FLYING HORSE NORTH FILING NO. 8
PRI #2, LLC.
EL PASO COUNTY, CO

COVER & LEGEND

PCD FILE NO.: SF2531

SHEET S&S	4
--------------	---

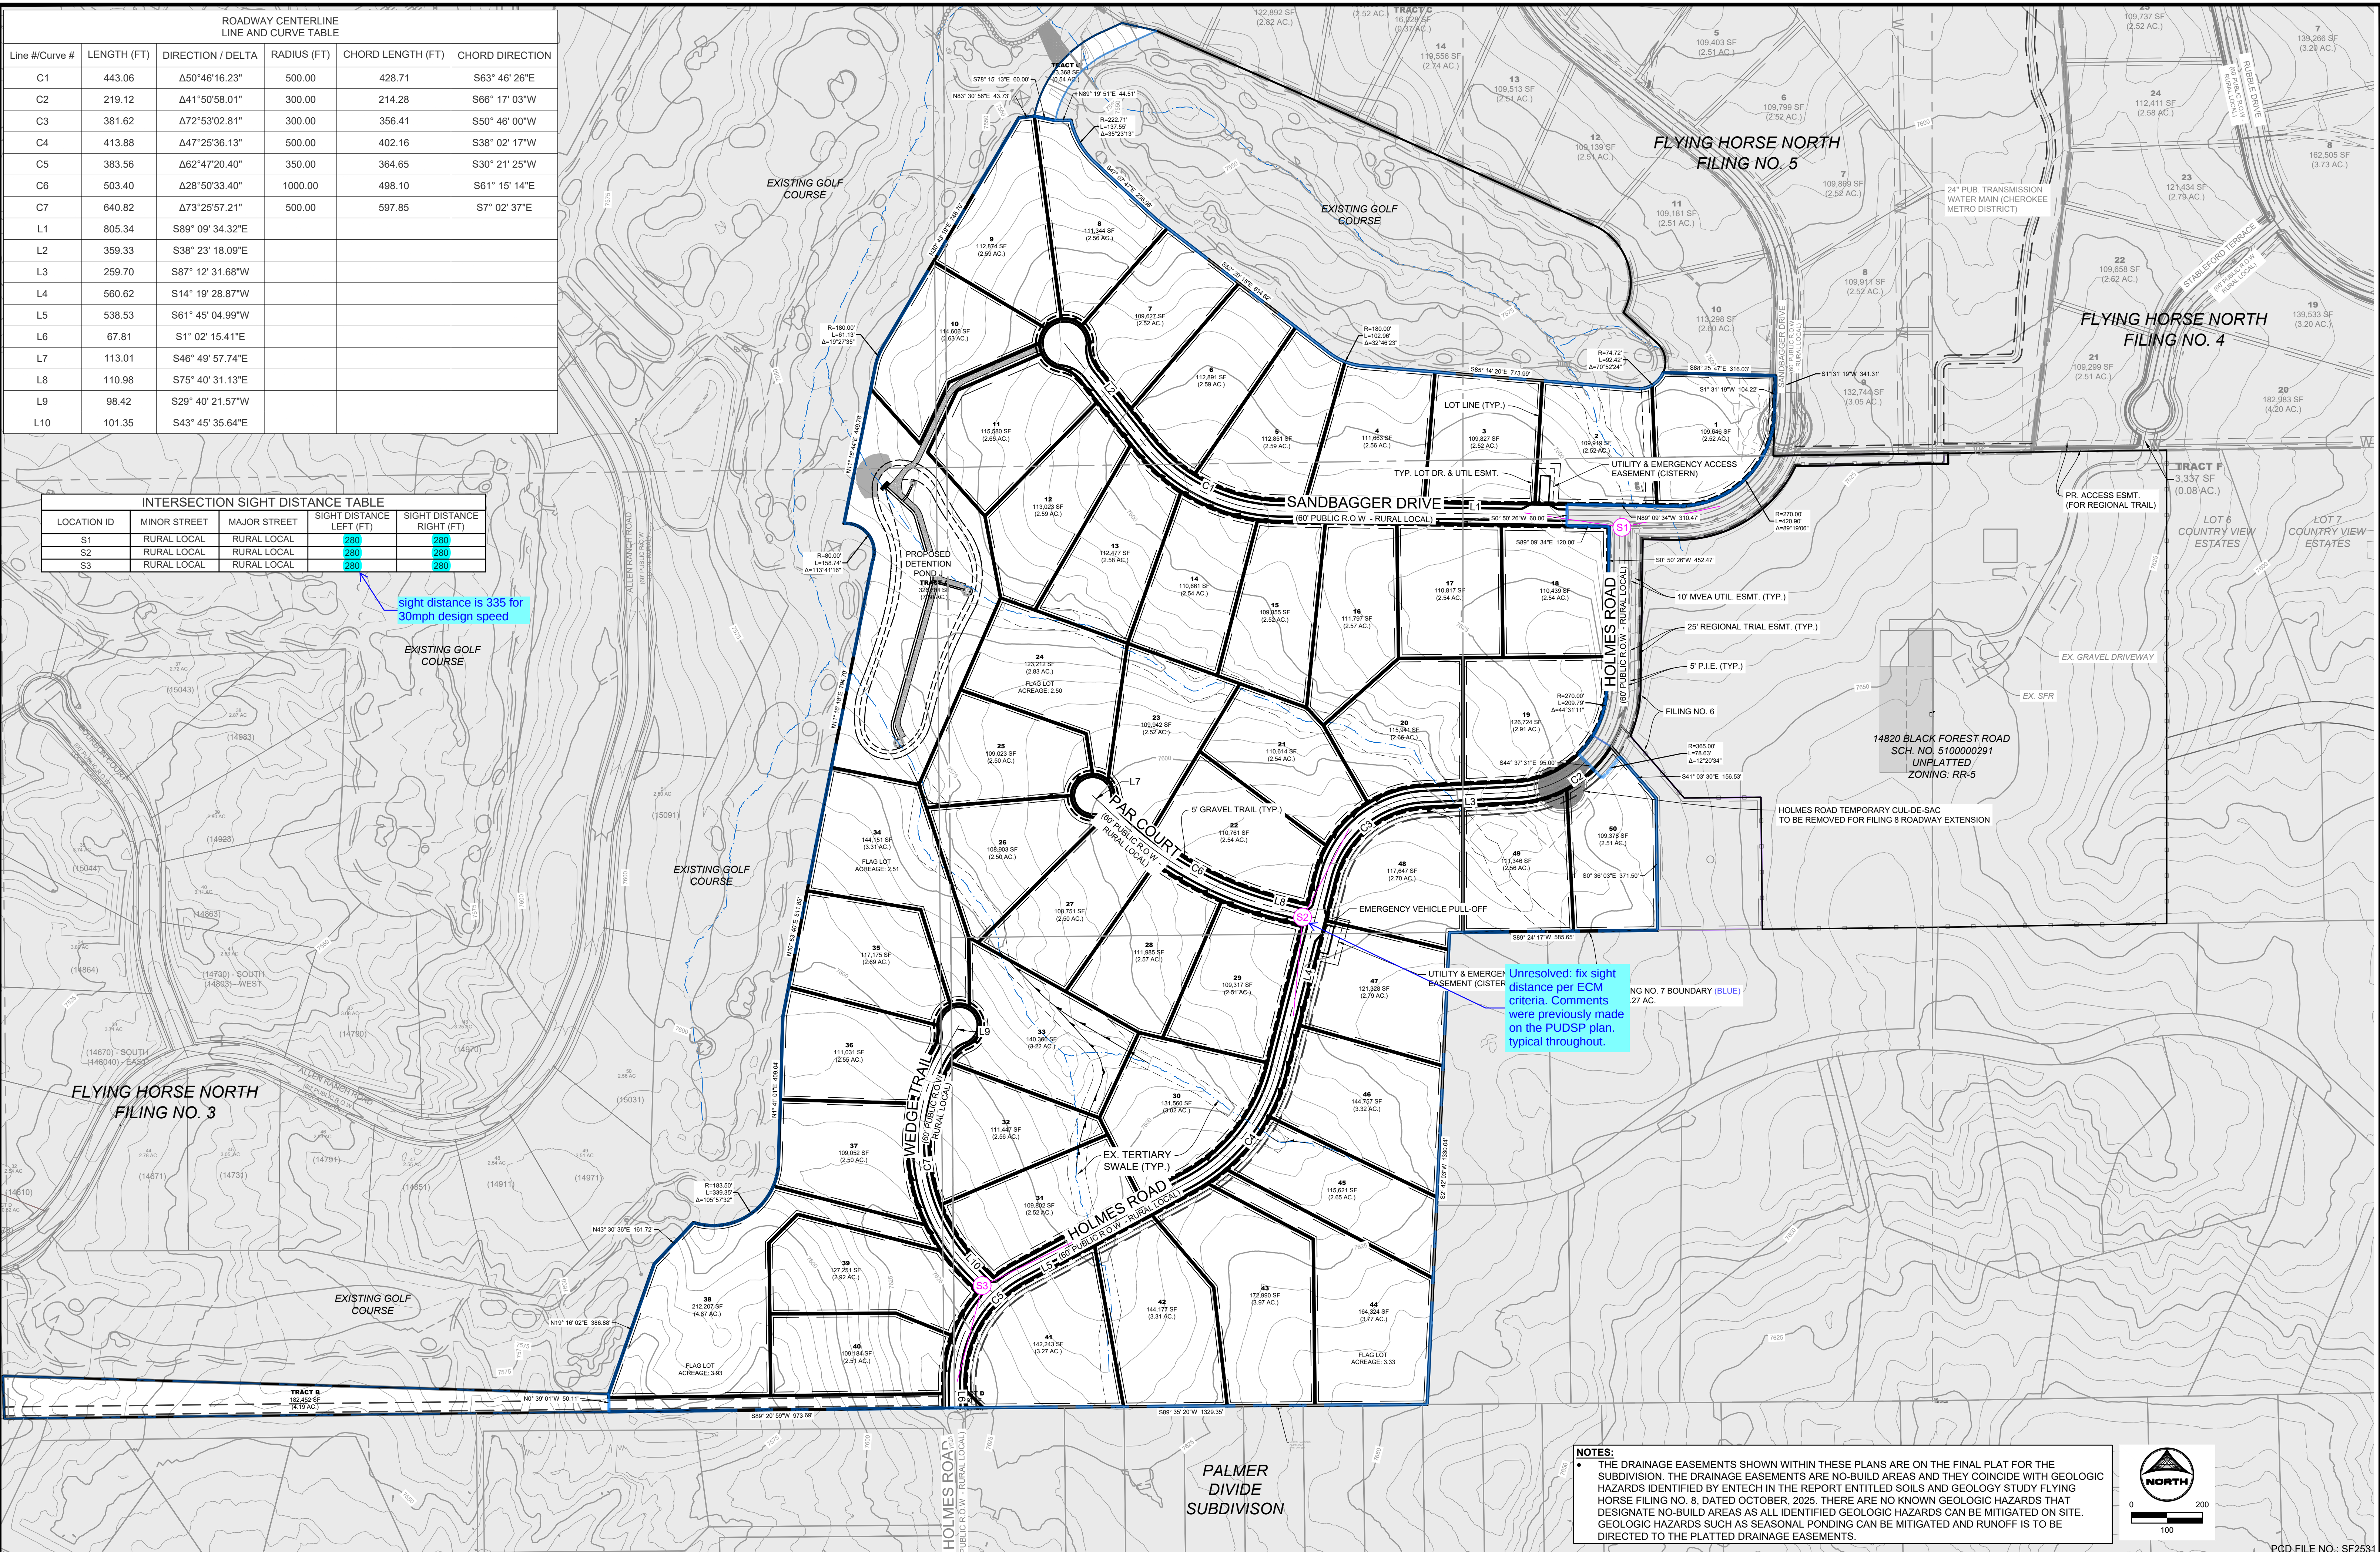
sight distance is 335 for 30mph design speed

HRG Response:
Sight distance line updated.
